Date: October 10, 2006  
To: Dave Nelson - Encompass Engineering  
From: Peggy Vincent - Engineer Tech I  
Re: Vista View Estates Division 1

The following comments and revisions should be made on the Vista View Estates Division 1 Final Plat Submittal dated September 28, 2006.

DIVISION I

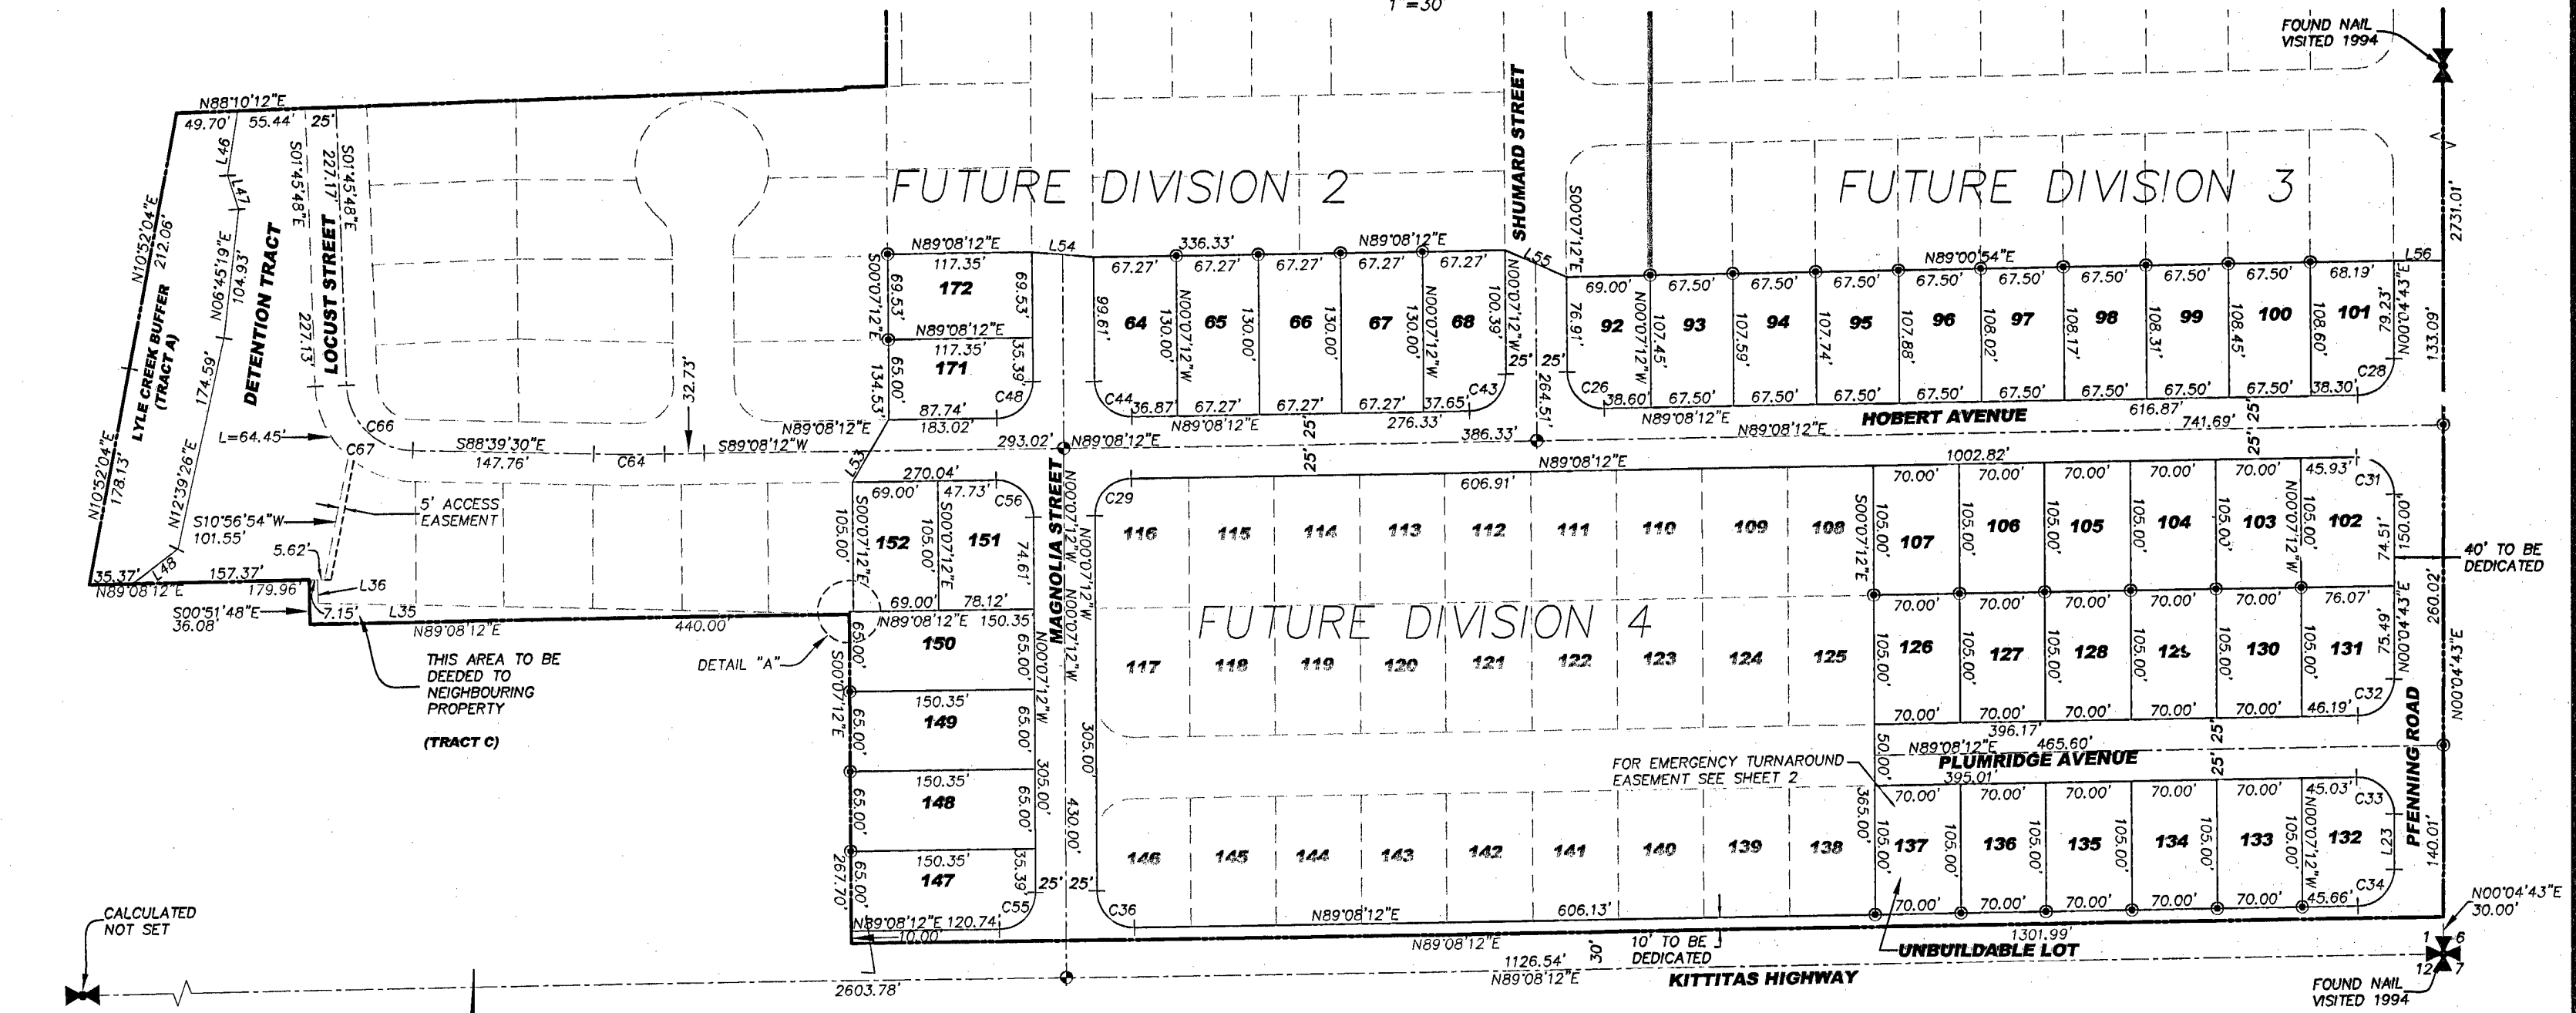
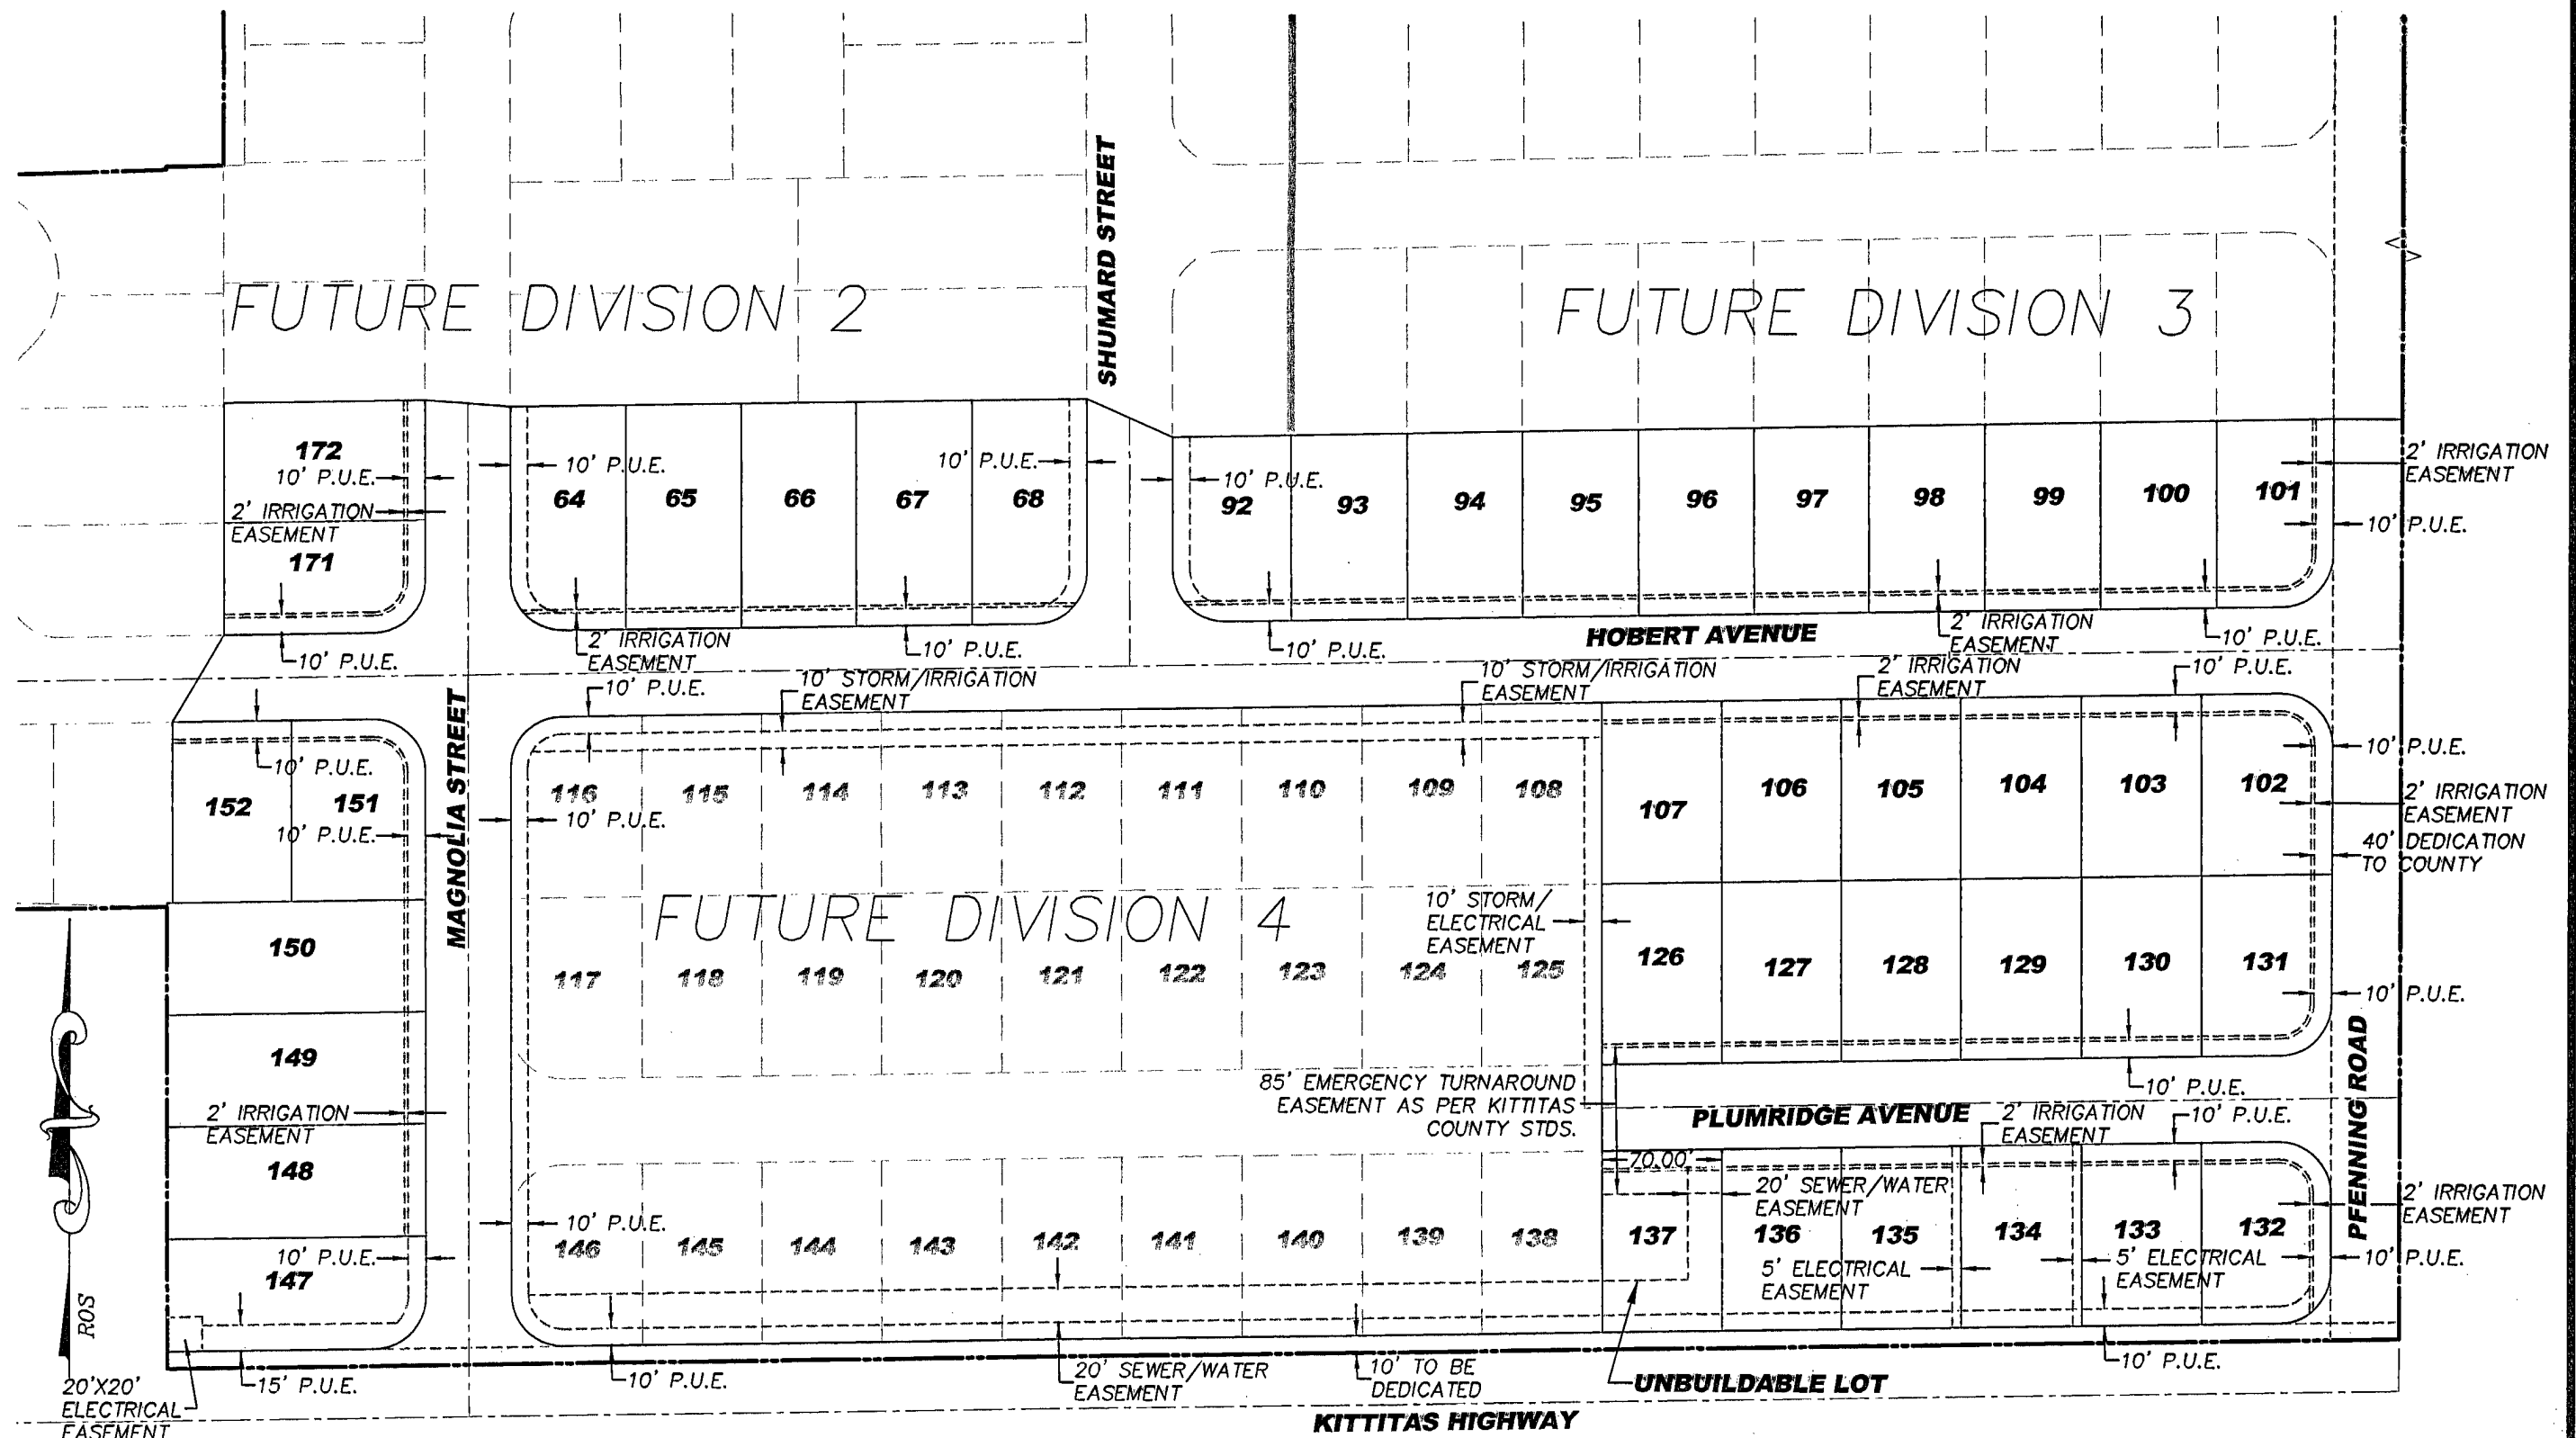
- See the attached storm drain note regarding maintenance of the detention area which needs to replace note number one. Plat needs to specify the lot/lots designated responsible for the maintenance. *lots Division one.*

- Need to assign the maintenance of the swale along Kittitas Highway to a responsible party. *lots along*
- Lots 108 thru 125 and 137 thru 146 are non-buildable until such time as the water and sewer services as well as Plumridge Avenue are completed. Lots 126 thru 136 are non-buildable until the frontage improvements are completed or bonded prior to acquiring building permits.

- The drawing reflects easements shown on the revision in review for the proposed church as well as the original design easements. The unneeded easements will need to be abandoned once the revised plans have been approved.

- Sheet 2 of the plat shows a 10' dedication to the city along Kittitas Highway. The word city needs to be removed. Use wording similar to sheet 1.
- The detention tract needs to be functional for division one and will need to be completed during division two. If division two is not constructed it will need to be completed as a part of phase one.

- It might be advisable to eliminate the easements shown that are no longer necessary due to the proposed change for the future church.
